# Gatwick Airport Northern Runway Project

Statement of Common Ground Between Gatwick Airport Limited and Tandridge District Council – Clean Version

DATE: JUNE 2024

Application Document Ref: 10.1.9

Diagram 3.3.9: Model performance before and after adjustment, London zone

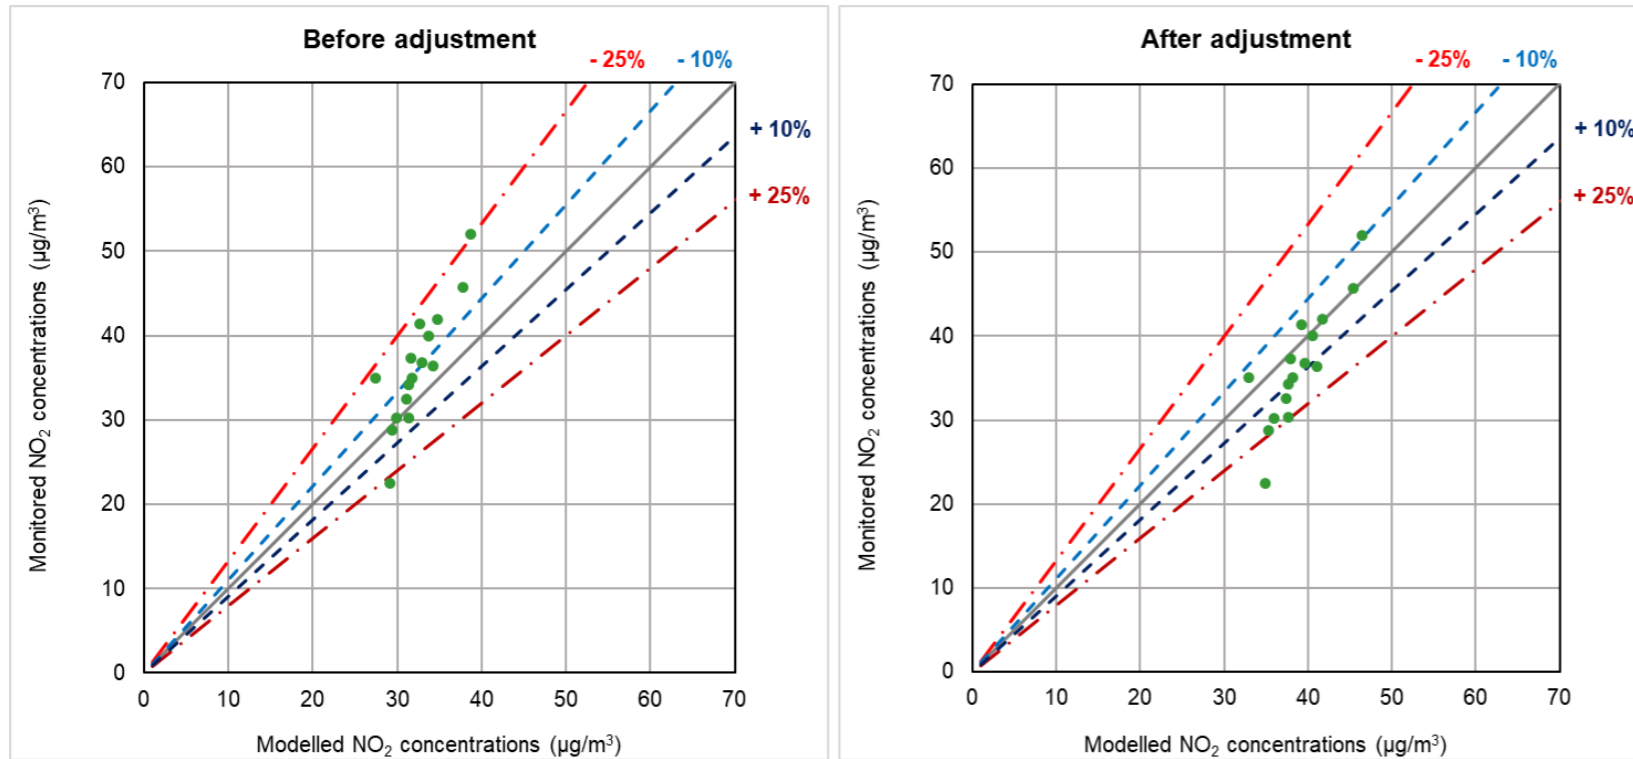
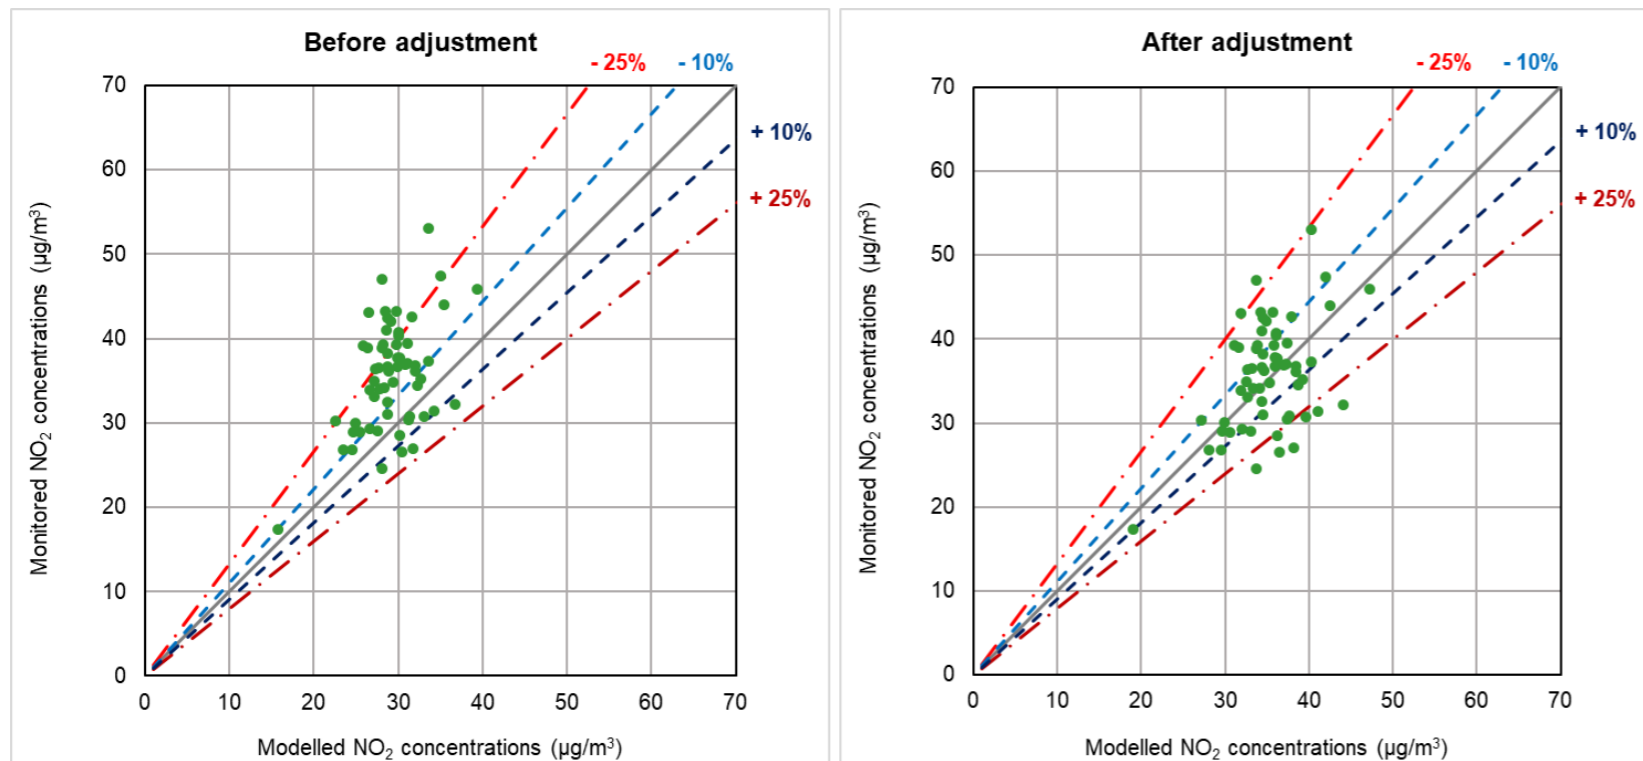
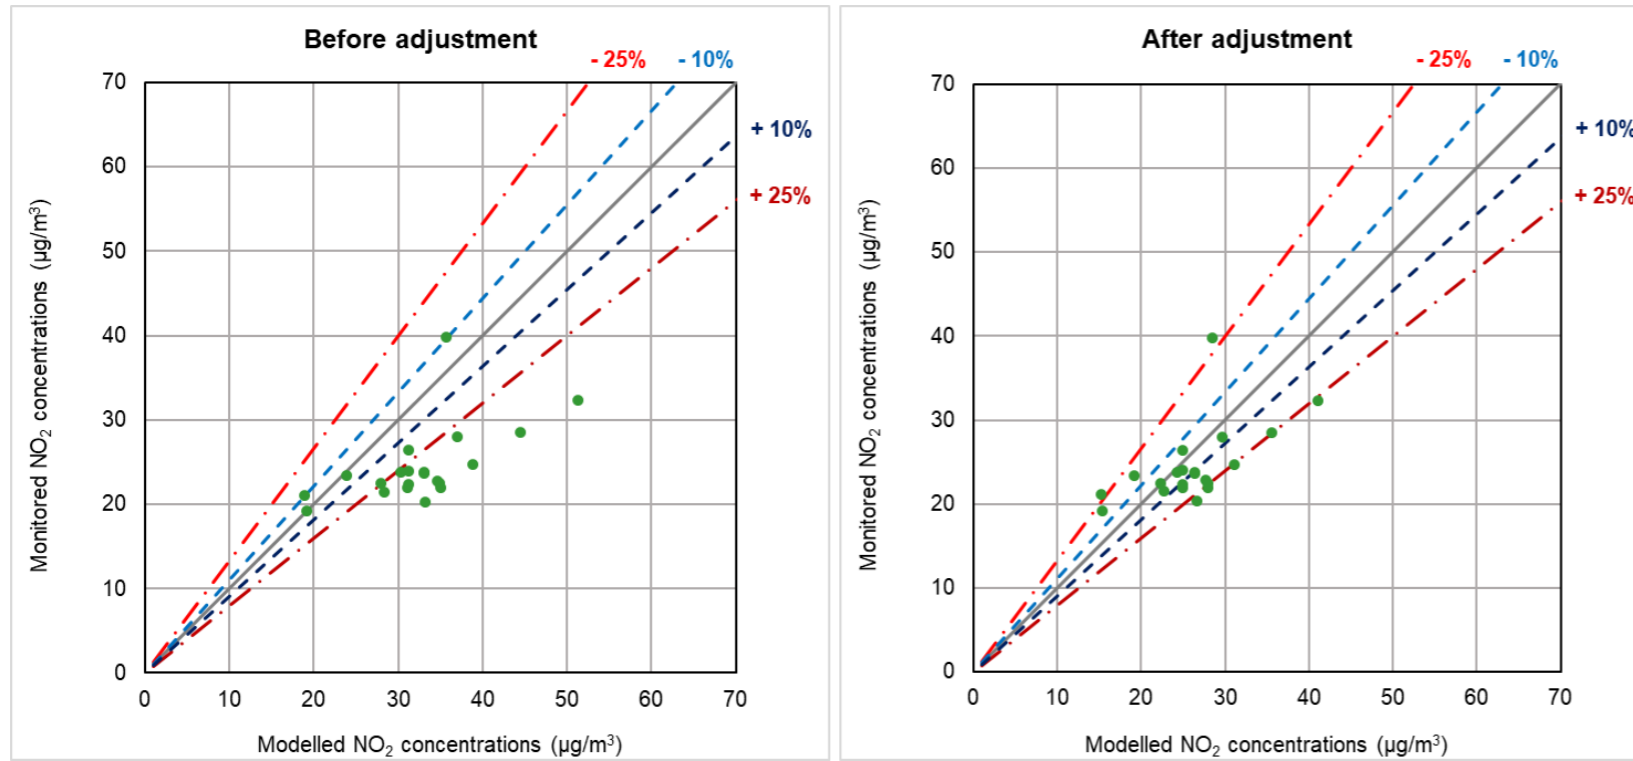
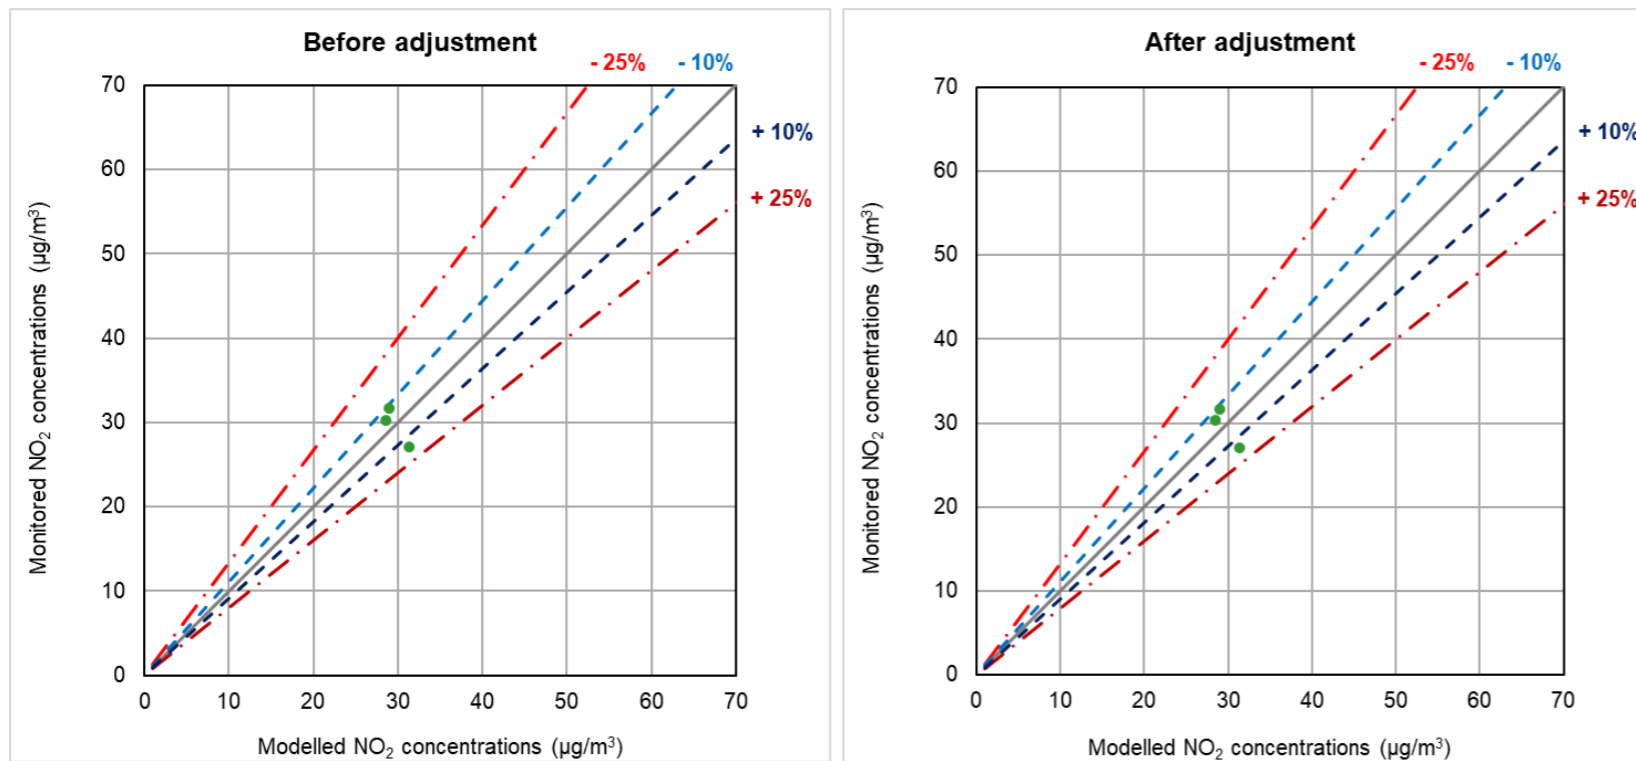
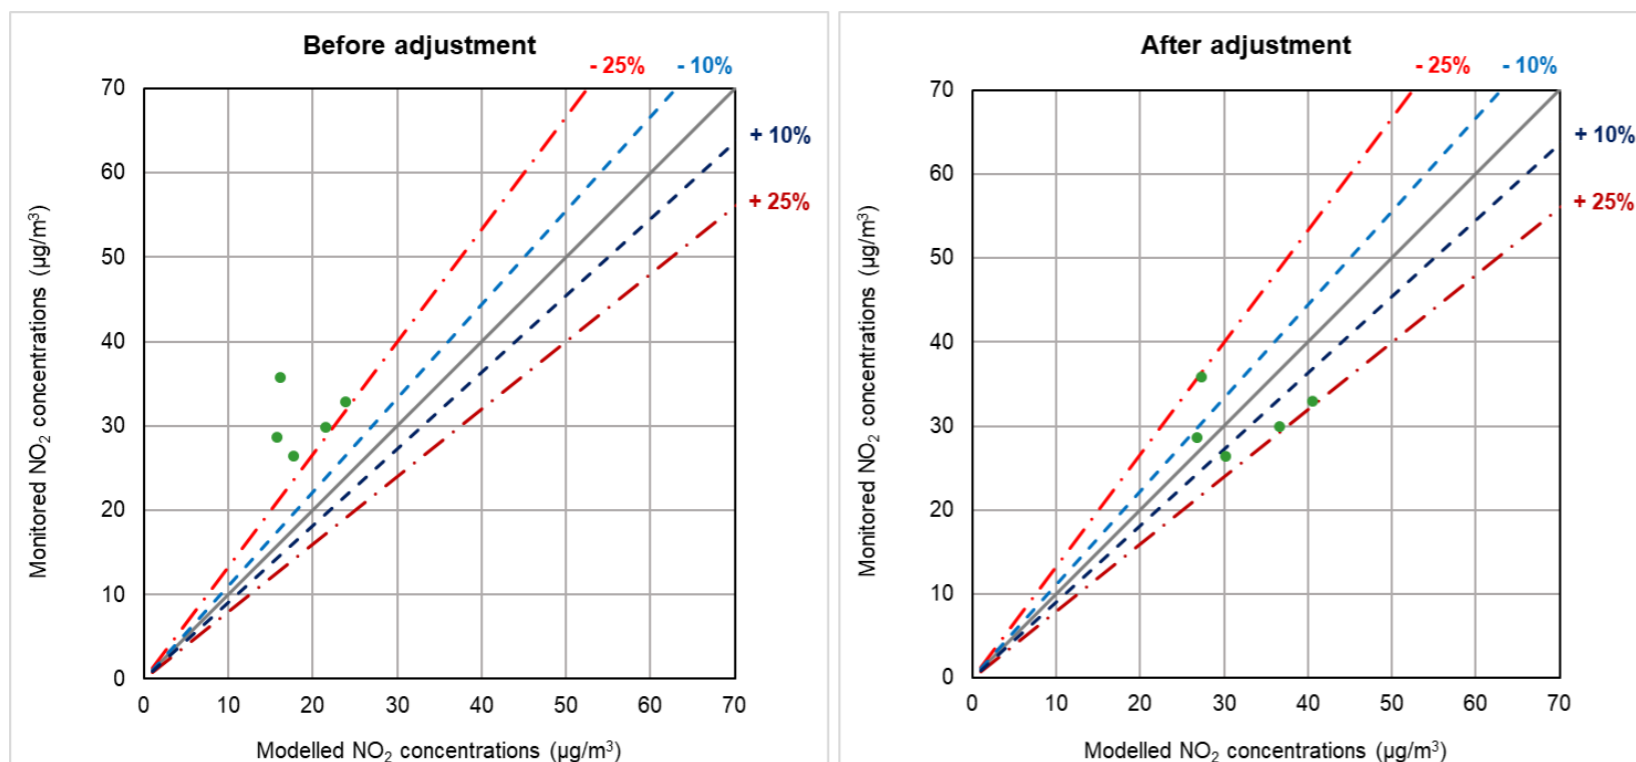
2.2.2.5	Verification zones	<p>TDC disagrees that enough justification was provided for the selection of different verification zones and why the model would be expected to perform differently in each area. A sensitivity test is required to demonstrate that the conclusions of the assessment would not change if a single verification factor were used.</p>	<p>Full details of the model verification process are included in Section 3 within the ES Appendix 13.6.1. Table 3.3.1 provides details on the verification zones used.</p>	<p><b>ES Appendix 13.6.1 Air quality Data and Model Verification</b> [APP-159],</p>	Under discussion

<p><b>Updated position (Deadline 1):</b> Further discussion is required on this point and the request for a sensitivity test examining the use of a single verification factor still remains.</p> <p><b>Updated position (Deadline 5):</b> Gatwick Airport Limited (GAL) comments in paragraph 3.7.7 of their Response to Deadline 3 Submissions [REP4-031] that the air quality matters submitted by the Joint Local Authorities at Deadline 3 (Appendix A) [REP3-117] will be responded to by Deadline 5. This Appendix of air quality queries prepared by AECOM included a wide range of technical matters.</p>	<p>The verification methodology was agreed with local councils at the modelling methodology workshop in November 2022. Model files and results were provided to the TWG via email 18<sup>th</sup> August 2023.</p> <p>The process followed during the ES took into account feedback from the local authorities at the PEIR stage and following discussions on the agreed approach.</p> <p><b>Updated position (April 2024):</b> The Applicant notes that the JLAs have provided a submission on air quality at Deadline 3. The Applicant will review this submission and respond accordingly.</p> <p><b>Updated position (Deadline 5):</b> The Applicant has provided a response to the air quality matter submitted by the JLAs at <b>Appendix A: Response to West Sussex Joint Local Authorities – Air Quality to The Applicant’s Response to Deadline 4 Submissions</b> (Doc Ref. 10.38). The Applicant will respond at Deadline 6 to the JLAs’ review submitted at Deadline 4 [REP4-053].</p>	<p><b>Appendix A: Response to West Sussex Joint Local Authorities – Air Quality to The Applicant’s Response to Deadline 4 Submissions</b> (Doc Ref. 10.38)</p>
